Access Design Assessment Report

ALEXANDRIA PARK COMMUNITY SCHOOL
7 PARK ROAD
ALEXANDRIA NSW 2015

Project: Alexandria Park Community School, 7 Park Road, Alexandria Park NSW 2015
Document Type: Access Design Assessment Report
Report Number: P216_282-3 (ACCESS) LD

1 GROUND FLOOR PLAN
1 : 1000

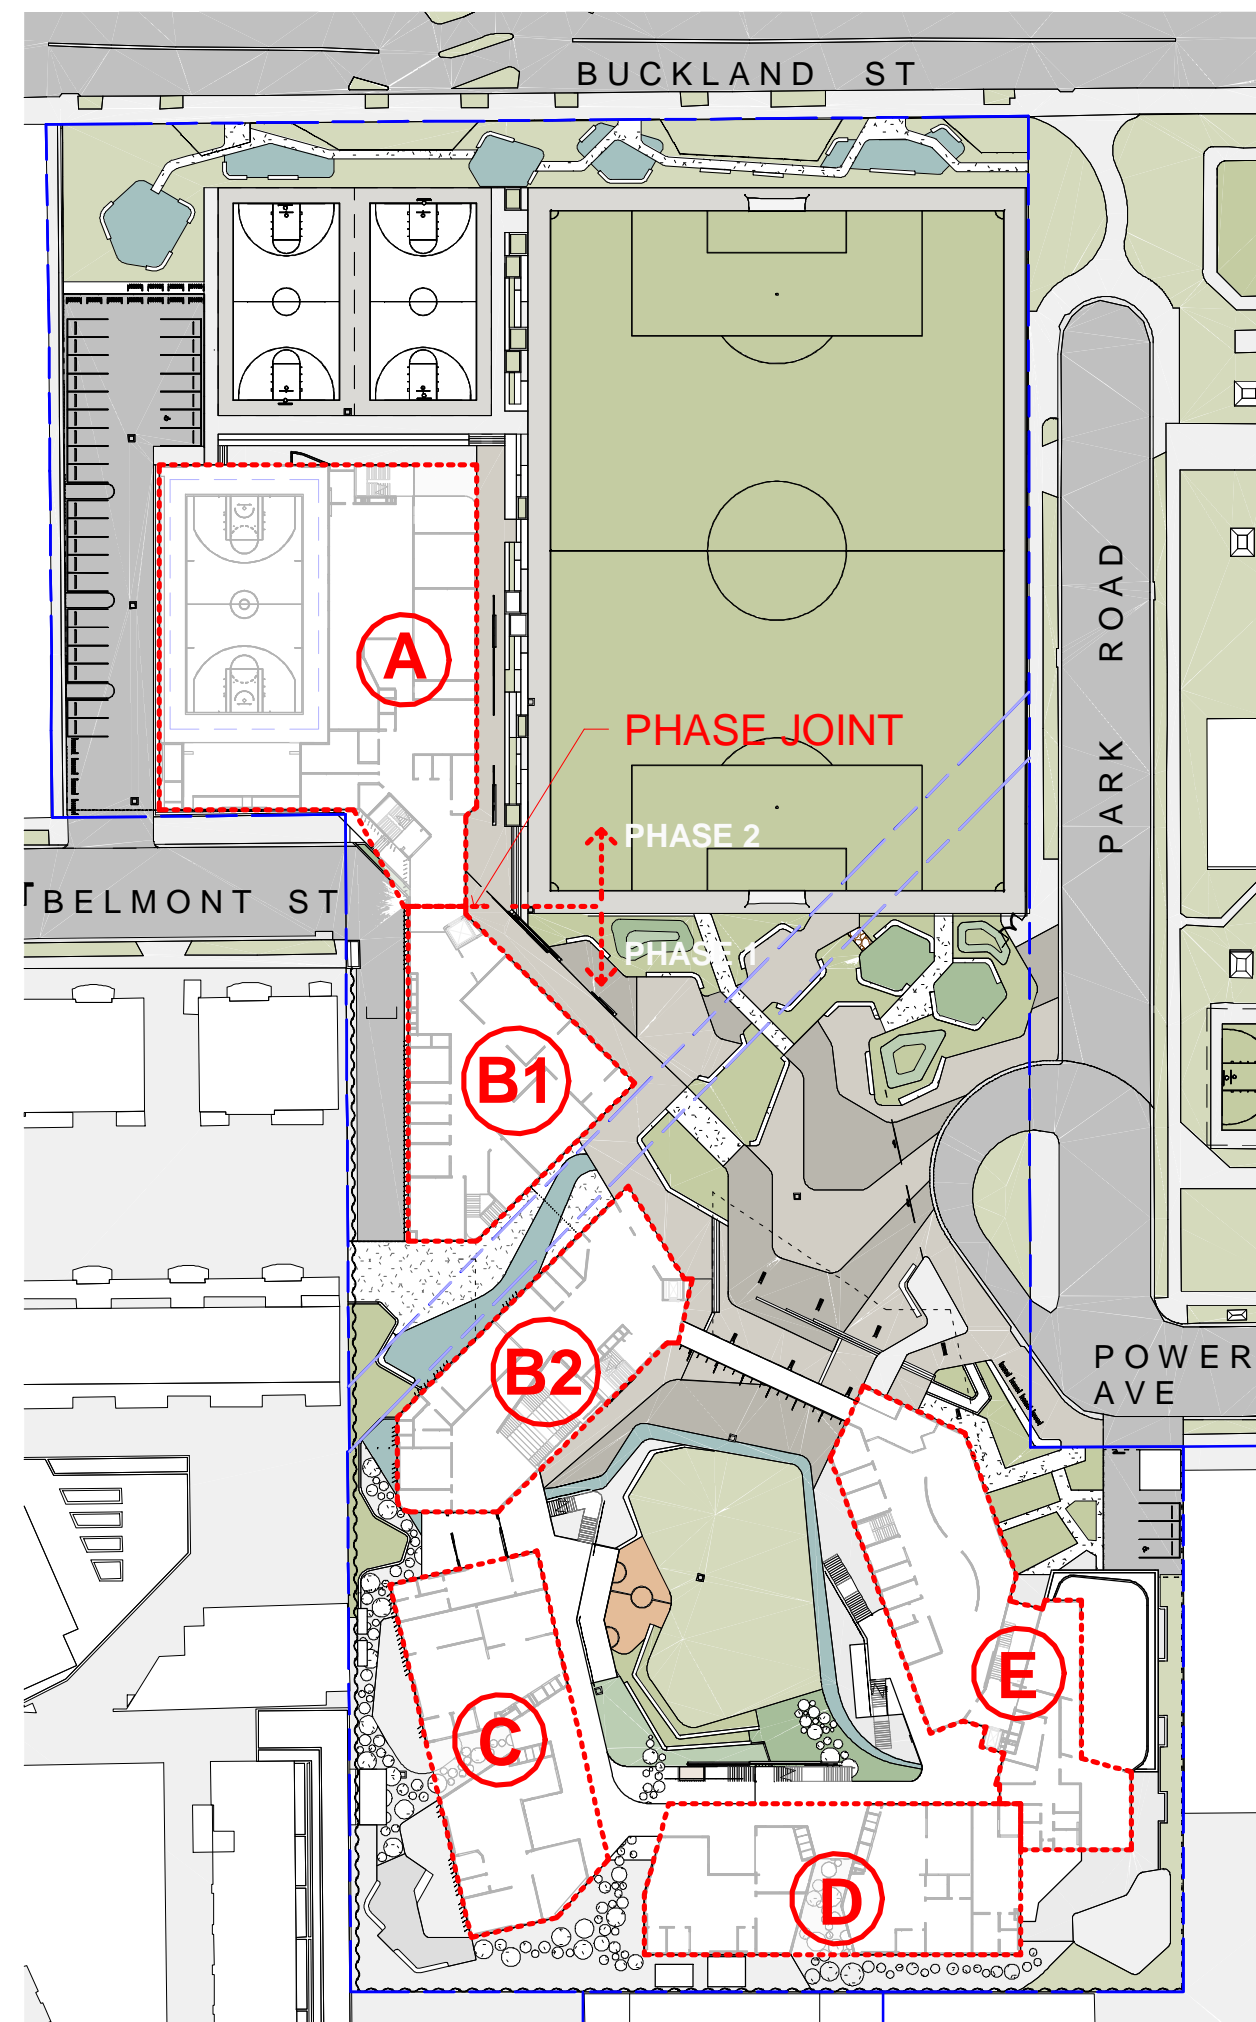
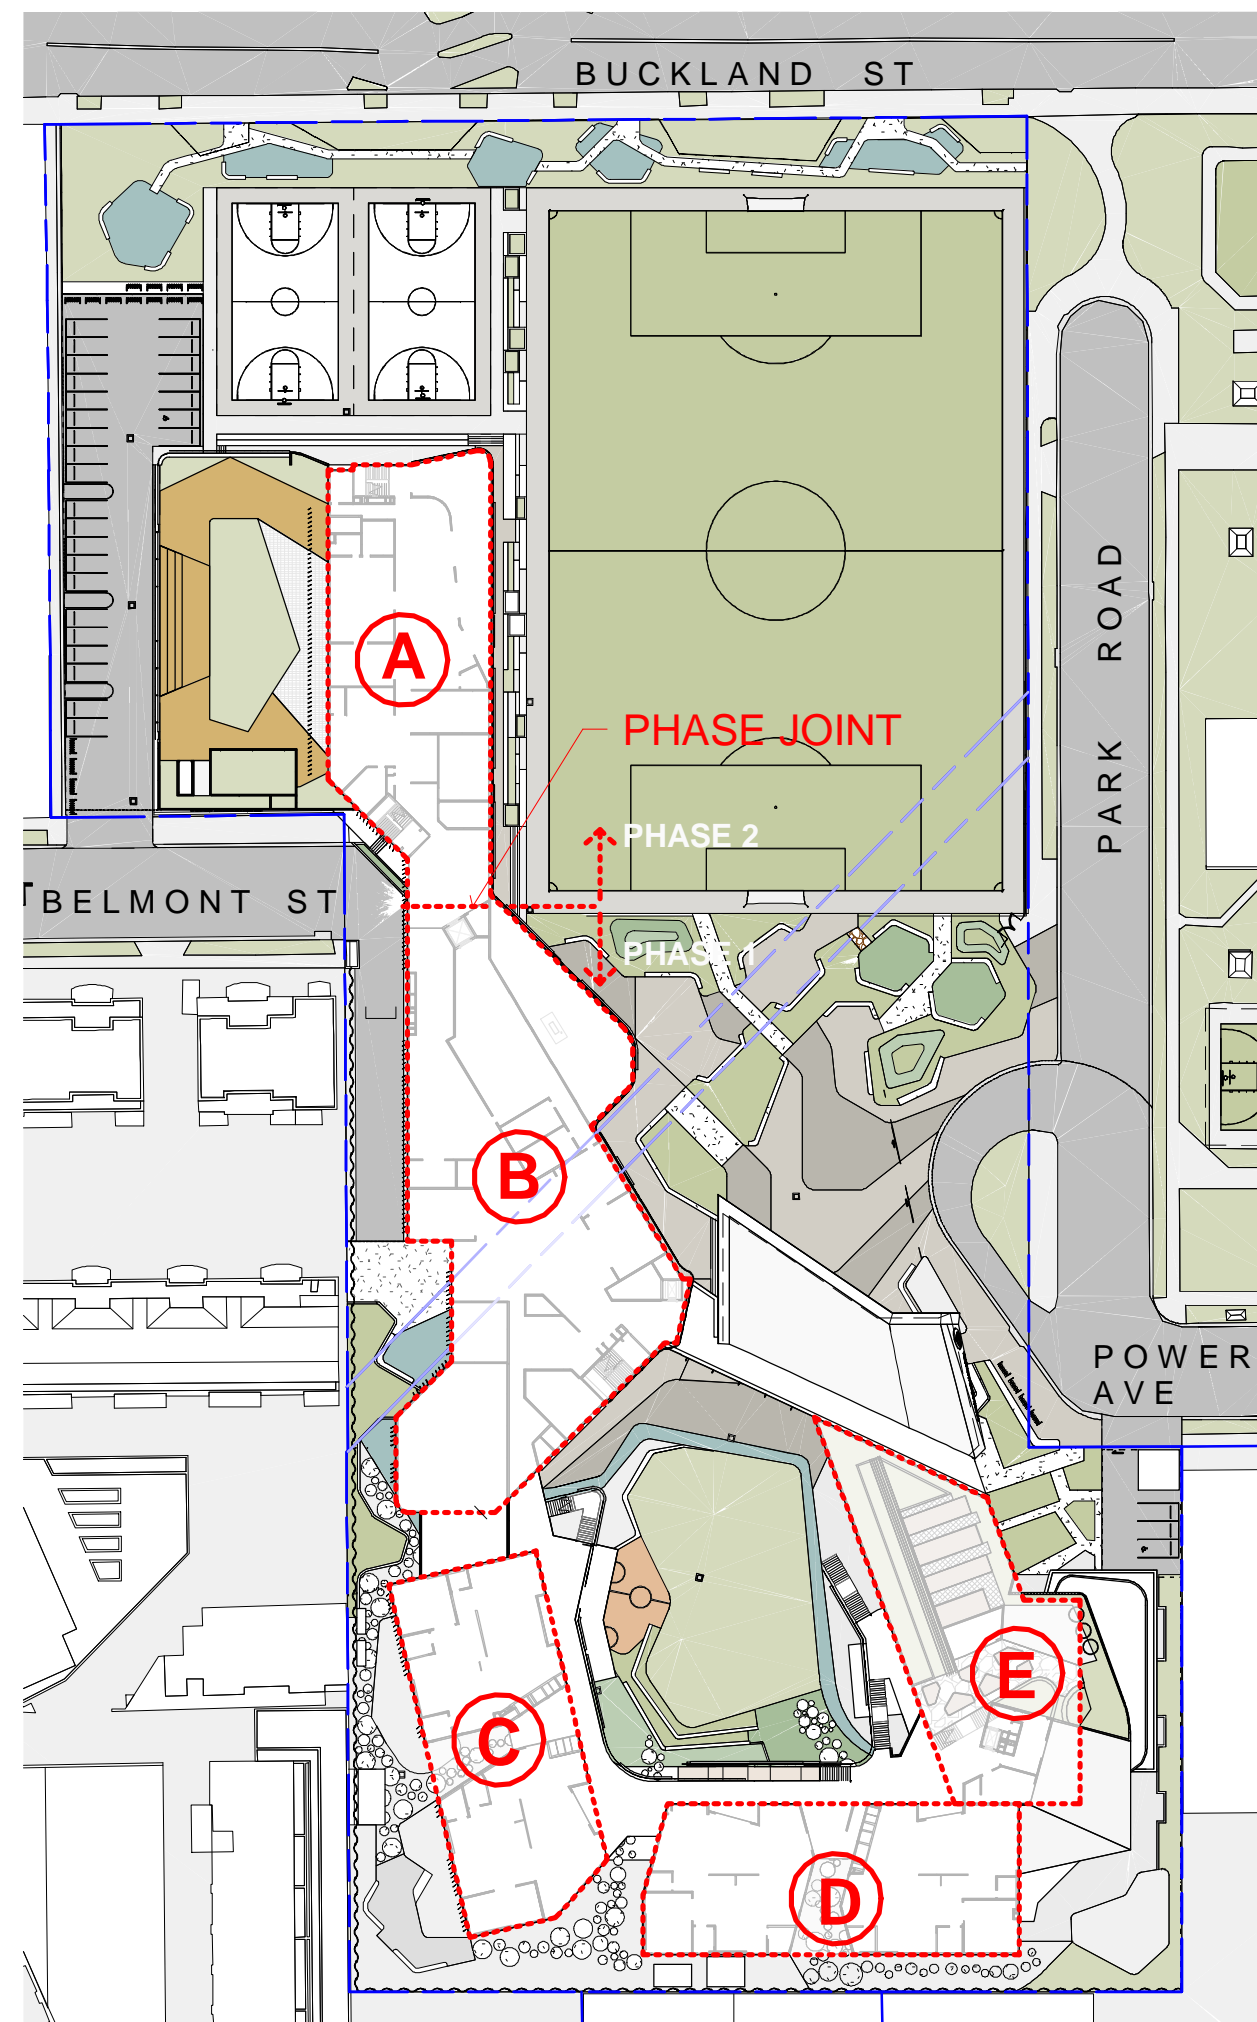
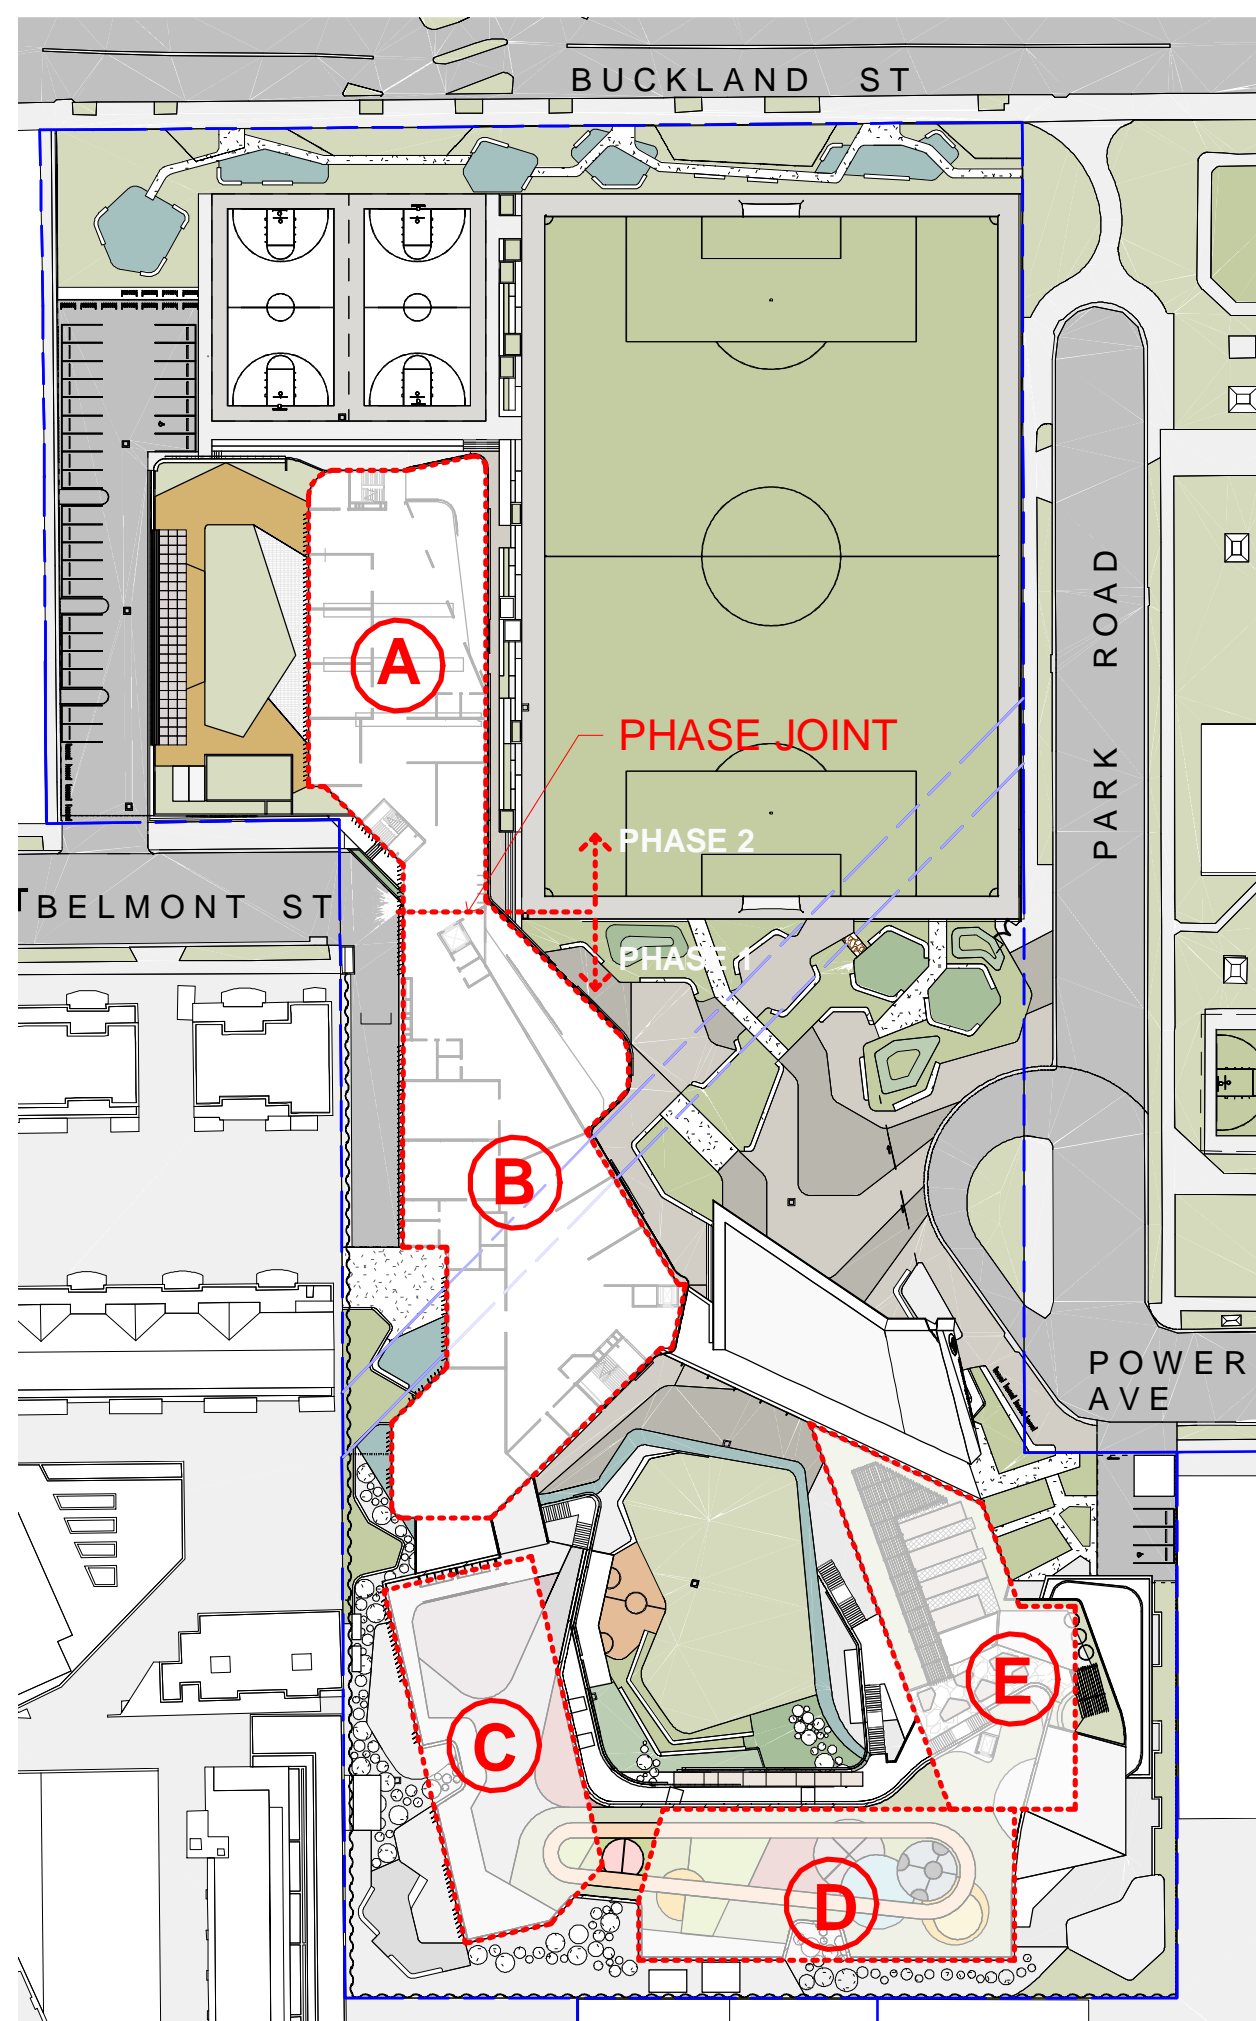
GROUND FLOOR

- Gym foyer - WC;
- Student reception – WC and Shower; and
- Preschool - WC and WC Shower.

FIRST FLOOR

- General learning unit 1 – WC and Shower;
- General learning unit 2 – WC and Shower; and
- Staff / admin – WC.

SECOND, THIRD, FOURTH FLOOR

- No accessible facilities have been provided on the second, third or fourth floor.

Provide one (1) accessible unisex sanitary compartment at each bank of male / female toilets on each storey.
